CITY OF ALBUQUERQUE

April 14, 2022

Re: CARMEL APARTMENTS A
7310 Carmel Ave. NE
Traffic Circulation Layout
Architect's Stamp 03-03-2022 (C19-069A)

CARMEL APARTMENTS  
SITE PLAN B DETAILS  
7310 CARMEL AVE. NE.  
ALBUQUERQUE, NM.  
PROJECT #2179

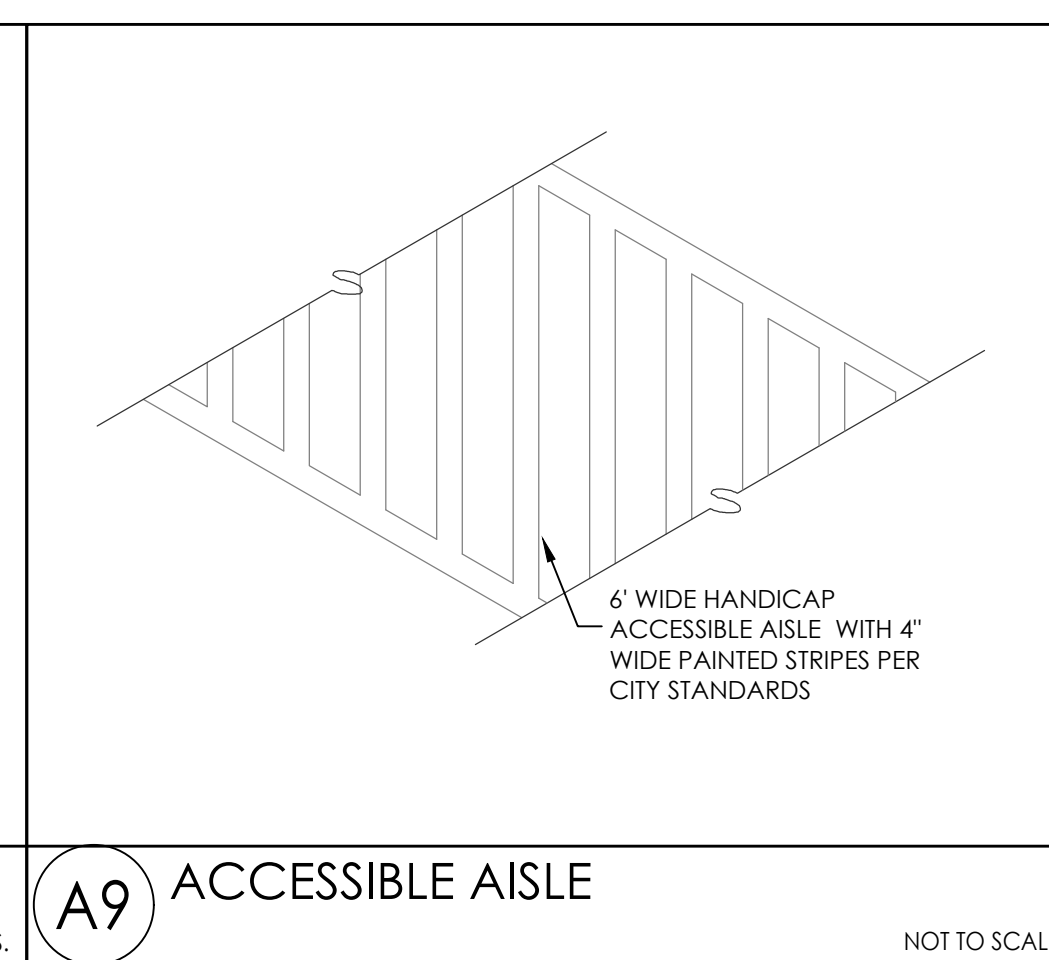
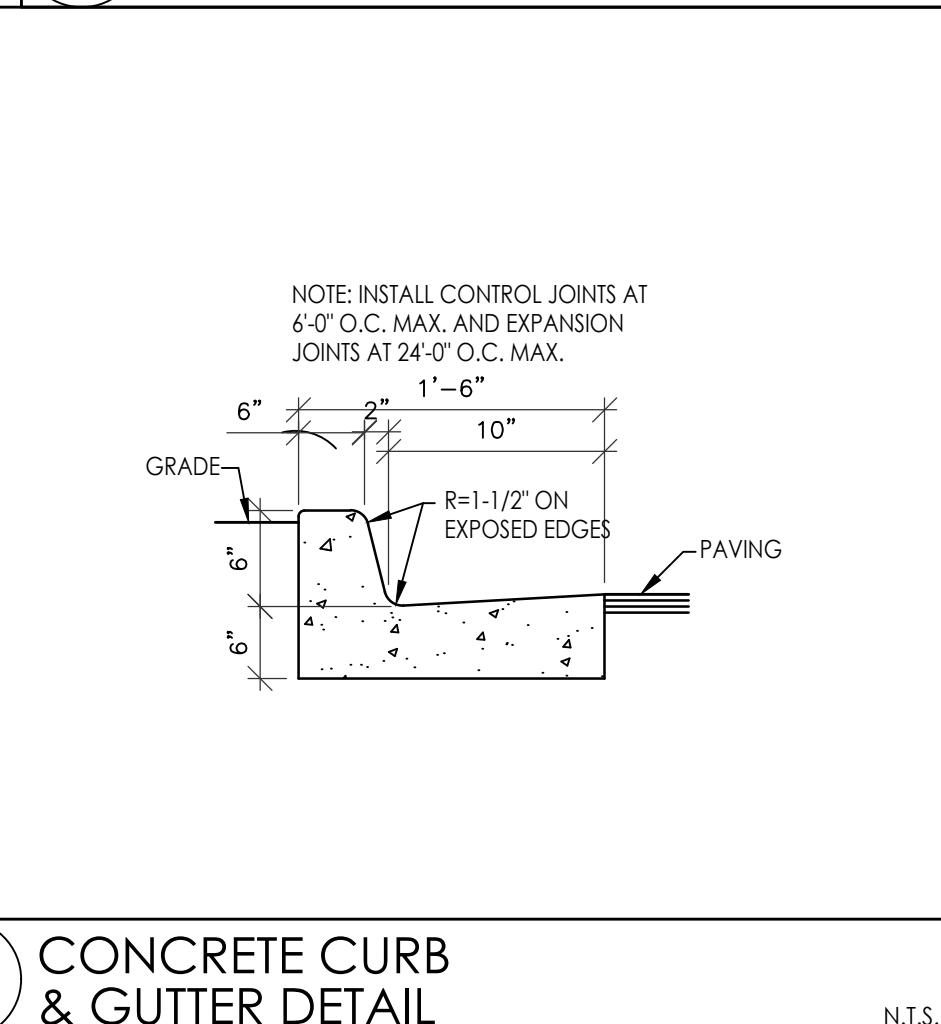
7. **Detail A4:** Paint Bollards yellow.
 8. **Detail A8:** Note 50:1 max on top of sidewalk and 12:1 max for taper. Stall widths are 8'-6" not 8'-0"-6" please adjust text.

9. **Detail A10:** 50:1 and 12:1 should have the word max. after each text.
 10. **ADA Parking Access Aisle dimensions (on site plan):** You specify 8'-6" on layout but on detail you call out 8'-0". Please address this concern.
